April 8, 2022

**RE: M-51– Response to 1st Technical Review Completion Letter
PA22002**

ER-01

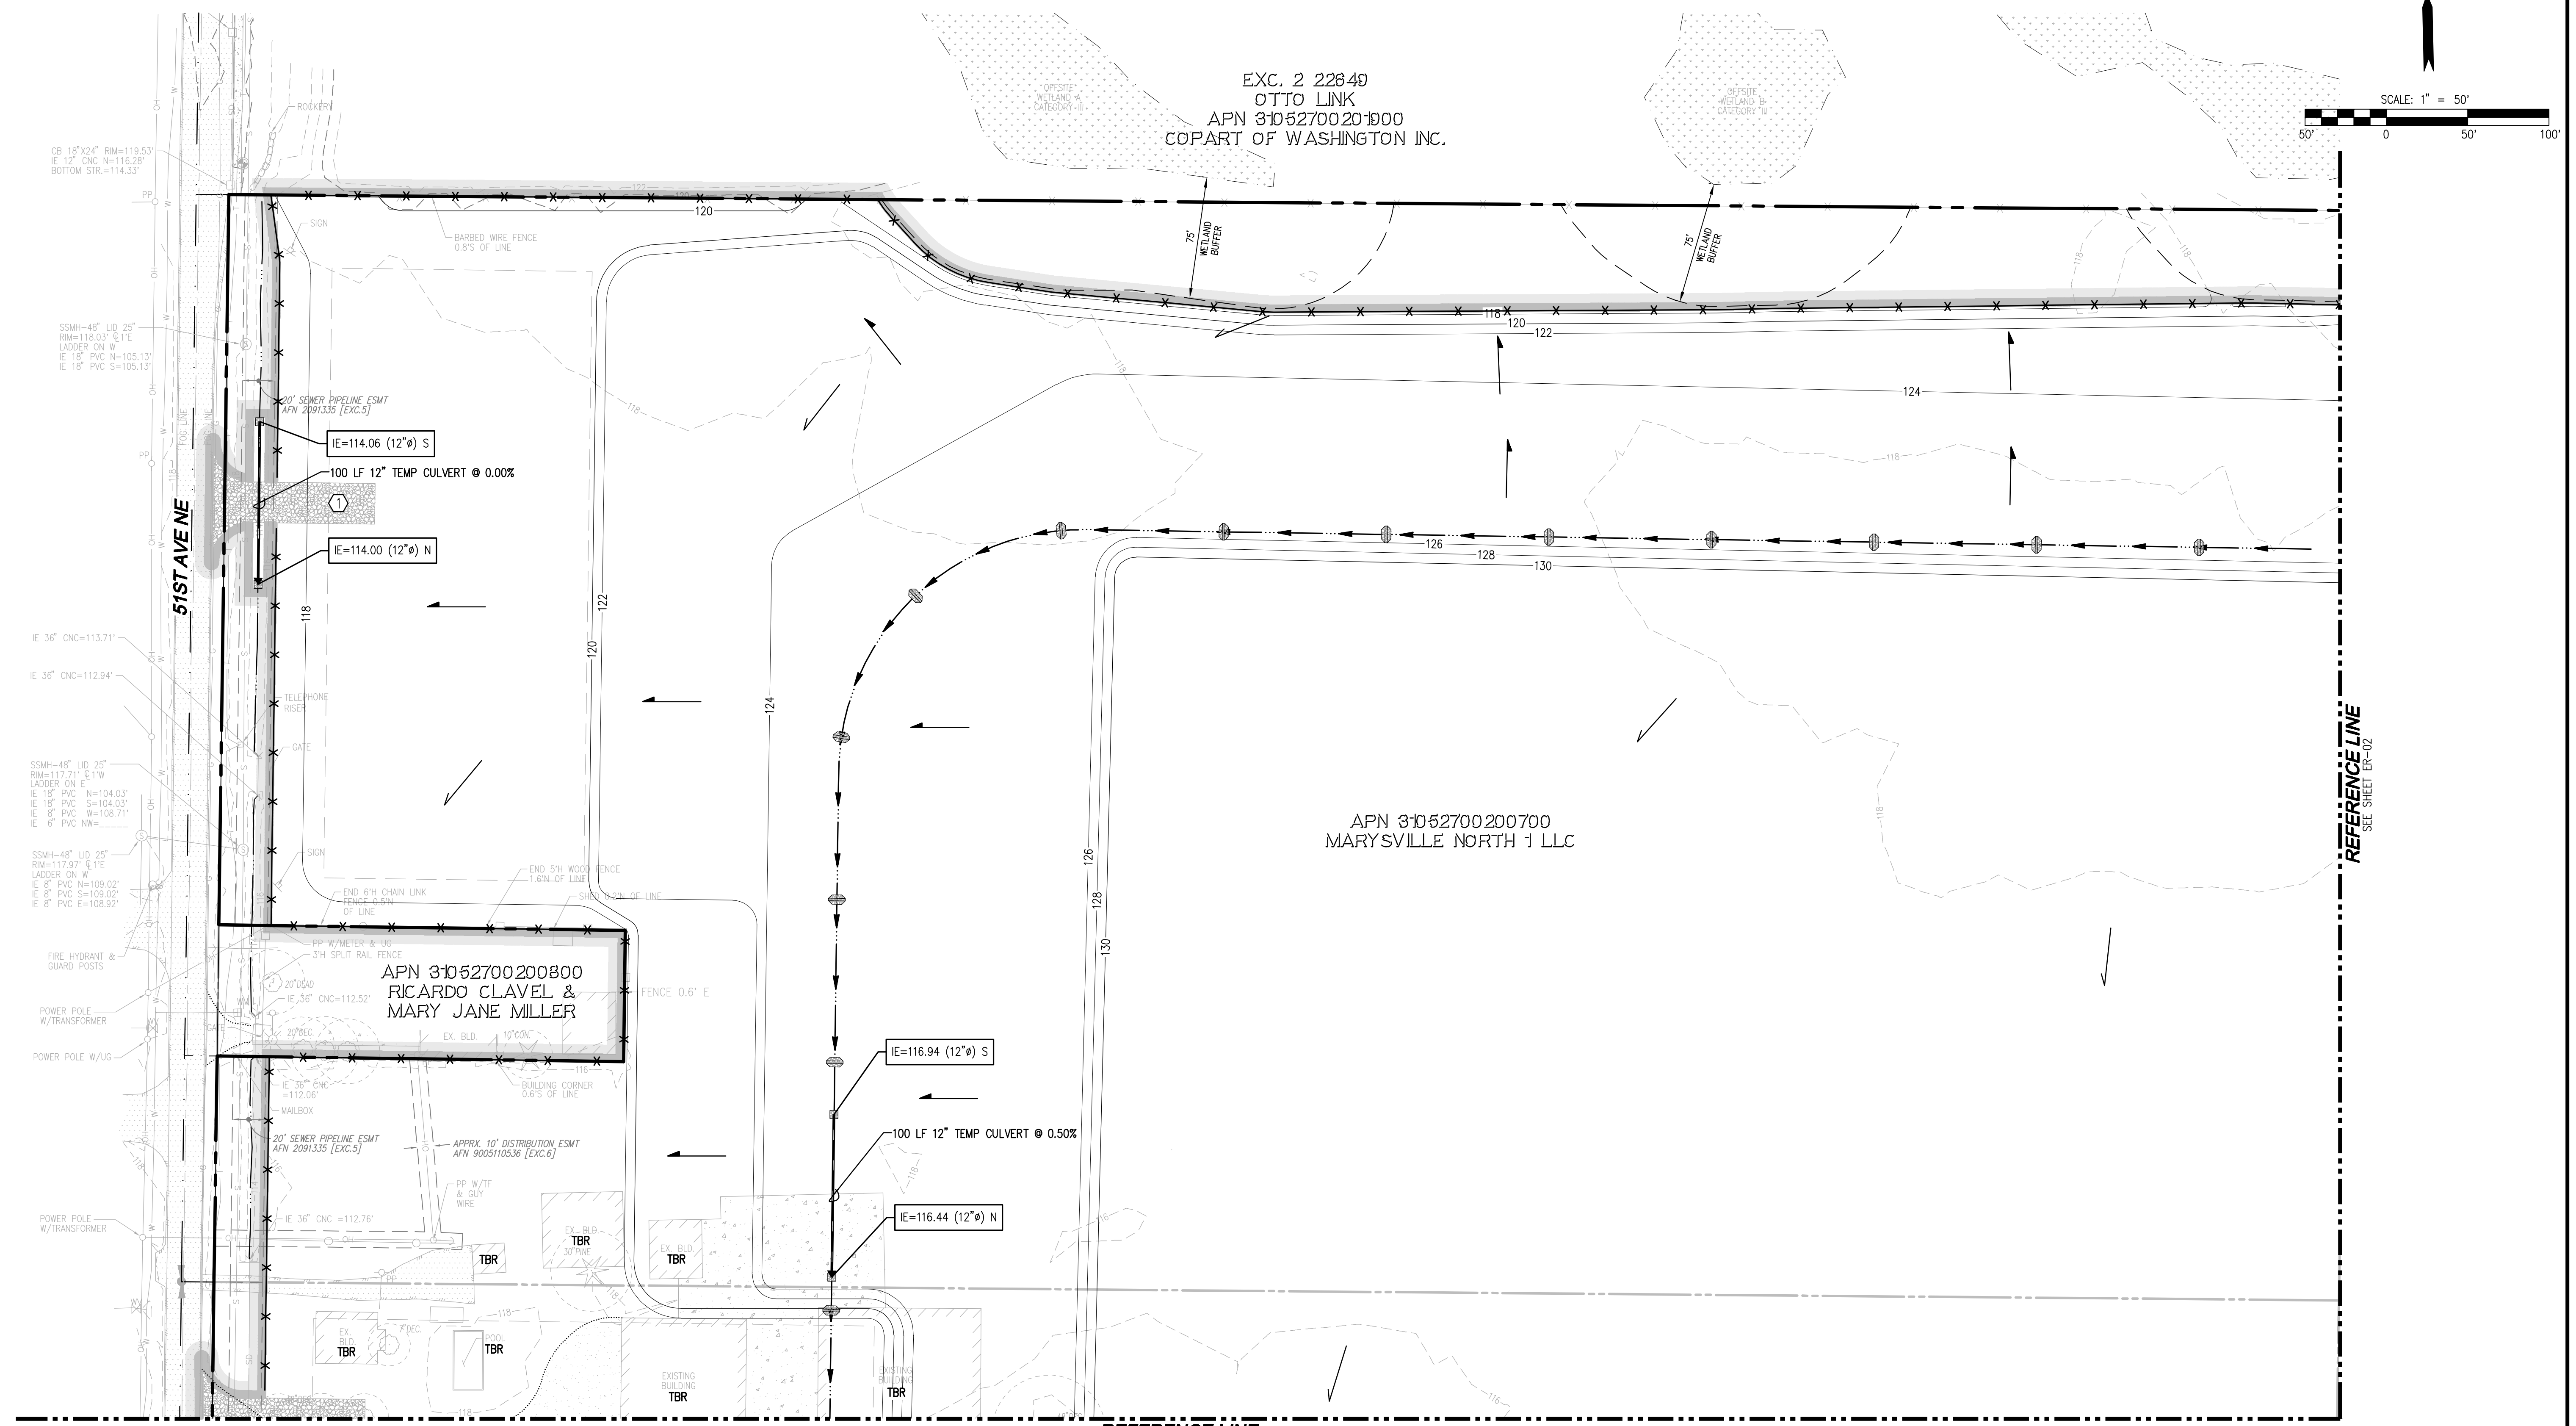
5. The grading plans shall be revised to avoid any impacts to the off-site wetlands and associated buffers and the 51st Avenue NE linear wetland and associated buffer. This includes piping and installation of the proposed construction entrance from 51st Avenue NE onto APN 31052700200700.

The existing site entrance on APN 31052700301100 can be used for grading activity.

Response: Plans have been revised to remove any encroachment within the existing wetland and stream buffers. Further mitigation plans will not be required as there is no proposed disturbance within the buffers.

GRADING WITHIN THE LIMITS OF THE 51ST AVE NE DITCH TO BE DONE UPON APPROVAL FROM WSDOE. WORK WITHIN THE DITCH WILL BE RESTRICTED UNTIL SUCH APPROVAL HAS BEEN OBTAINED. SILT FENCE TO BE INSTALLED AROUND PERIMETER OF THE DITCH TO PREVENT SEDIMENT MIGRATION FROM THE CONSTRUCTION SITE.

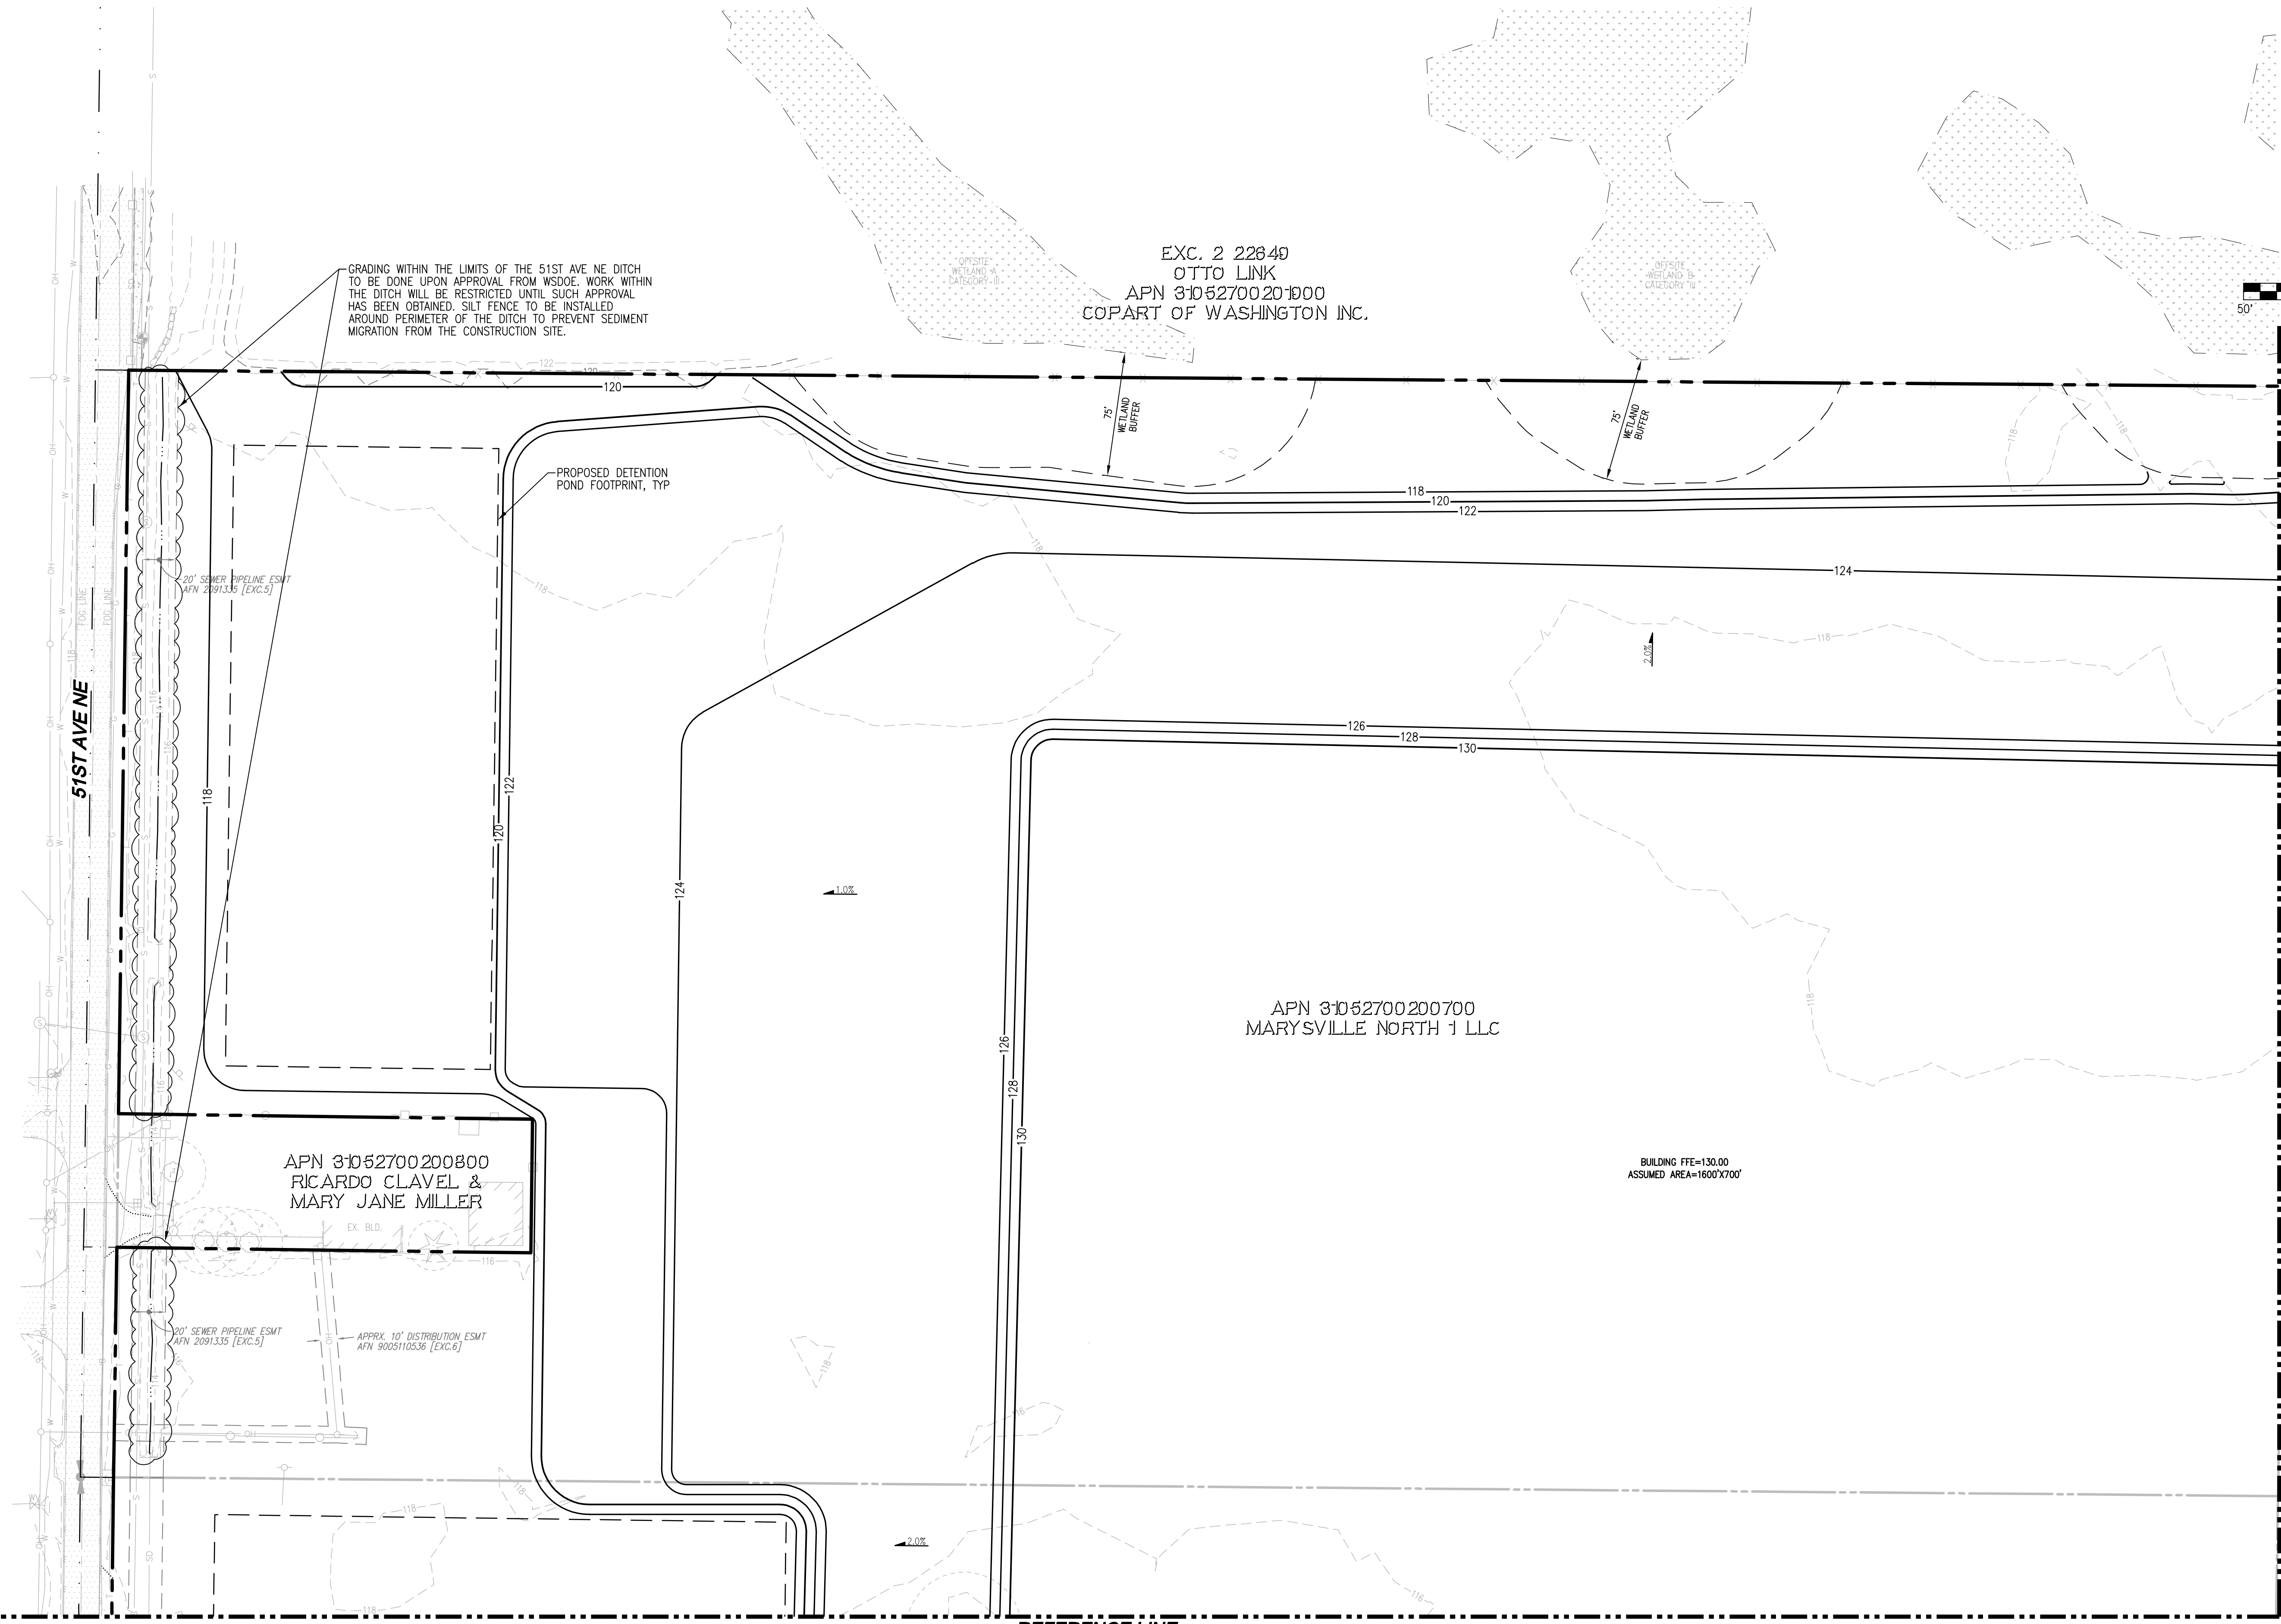
- b. Based on comments from Department of Ecology, in an e-mail related to a project along 51st Avenue NE, known as Cascade Commerce Center (PA20047), dated October 26, 202, the 51st Avenue NE ditch is a regulated linear wetland (attached). Mitigation is required for any impacts proposed to the wetland and associated buffer.

Any temporary, or permanent, impacts to the 51st Avenue NE linear wetland and associated buffer shall be avoided, until the applicant obtains approval from The Corps and DOE to fill the wetland.

Response: Plans have been revised to remove any encroachment within the existing wetland and stream buffers. Further mitigation plans will not be required as there is no proposed disturbance within the buffers. Any further disturbance of the 51st buffer will be done upon approval from the corps and DOE, a note has been placed on the plan stating such.
